WEST SUSSEX COUNTY COUNCIL CONSULTATION

TO:	Arun District Council FAO: S Davis	
FROM:	Highways, WSCC	
DATE:	10 th December 2018	
LOCATION:	66 & 66A, Hawthorn Road, Bognor Regis, West Sussex, PO21 2DD	
SUBJECT:	BR/308/18/DOC Approval of details reserved by condition imposed under ref BR/293/16/PL relating to Condition No. 3 materials & finishes, Condition No 4 screen walls & railings, Condition No 5 refuse & recycling bin enclosure Condition No 7 covered & secure cycle parking spaces.	
RECOMMENDATION:	☒ Advice ☐ Objection ☐ Modification ☐ No Objection ☐ More Information ☐ Refusal	
S106 CONTRIBUTION TOTAL:	£N/A

## As Built Site Plan

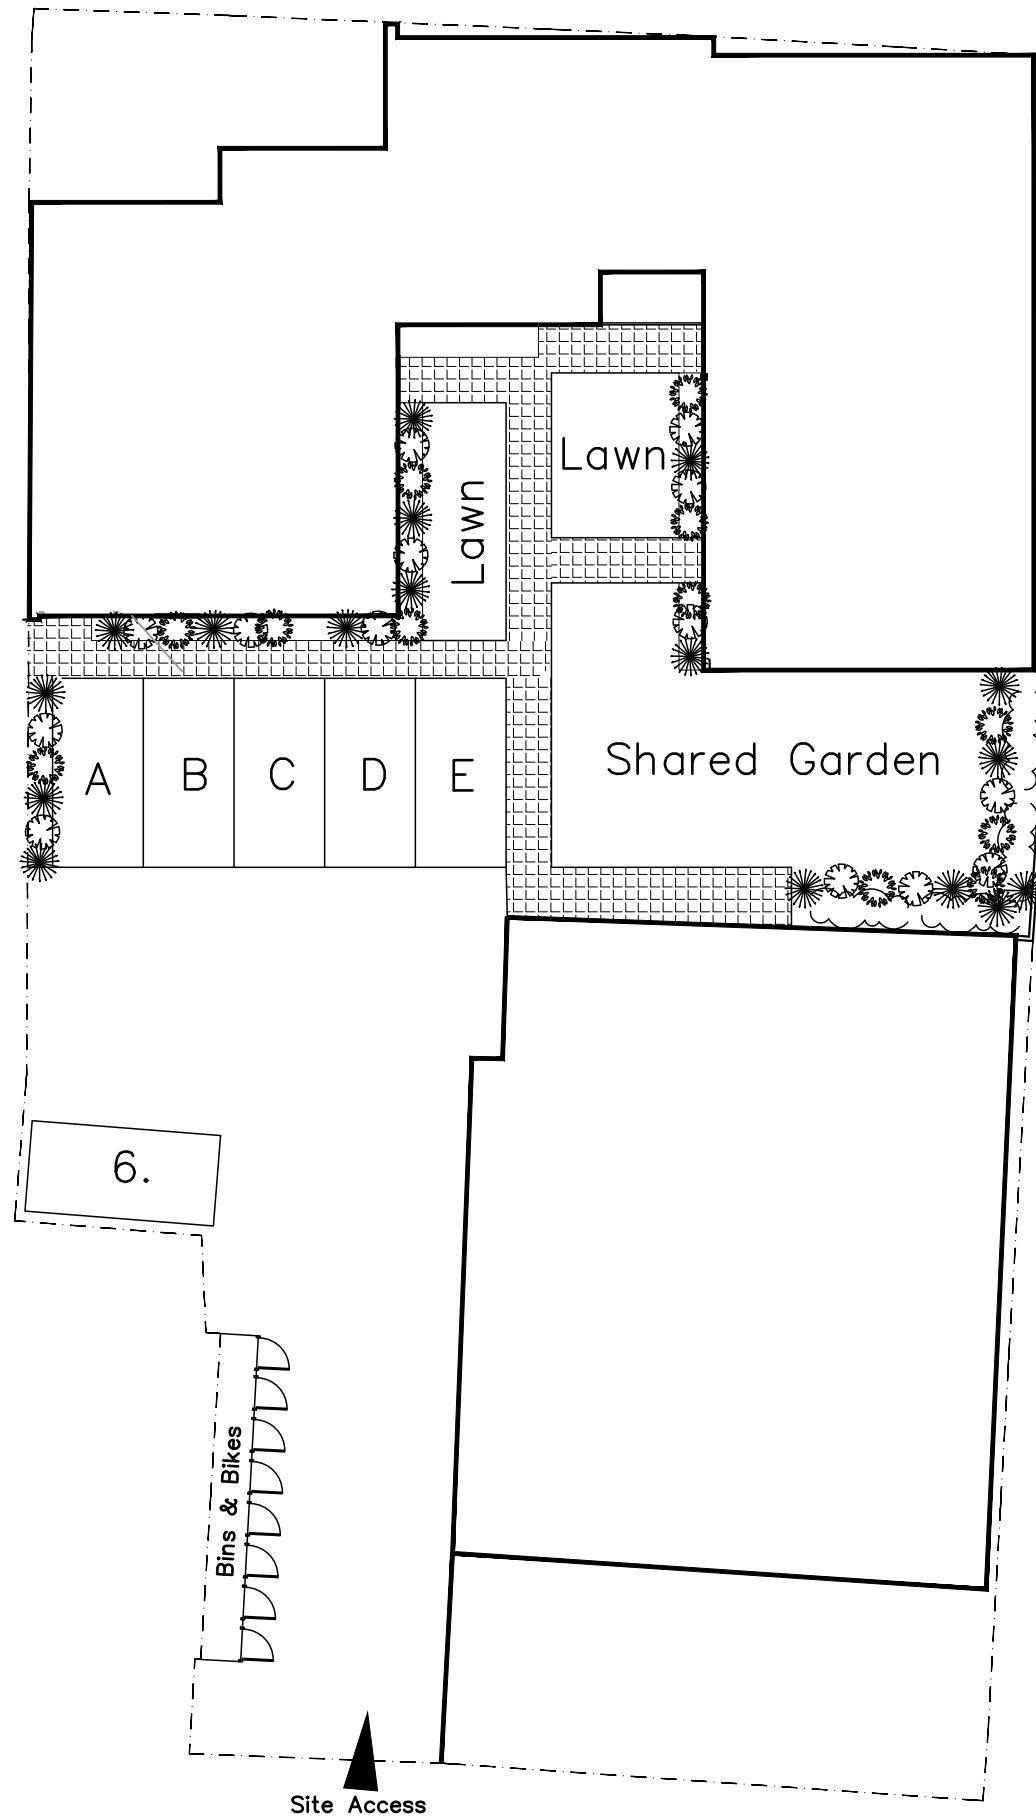
The As Built Site Plan indicates the shared bike and bin store. Whilst the internal dimensions and quantity of bicycle spaces are unknown it is evident there is sufficient space for secure and covered bicycle storage. The plans and details pertaining to the condition are acceptable.
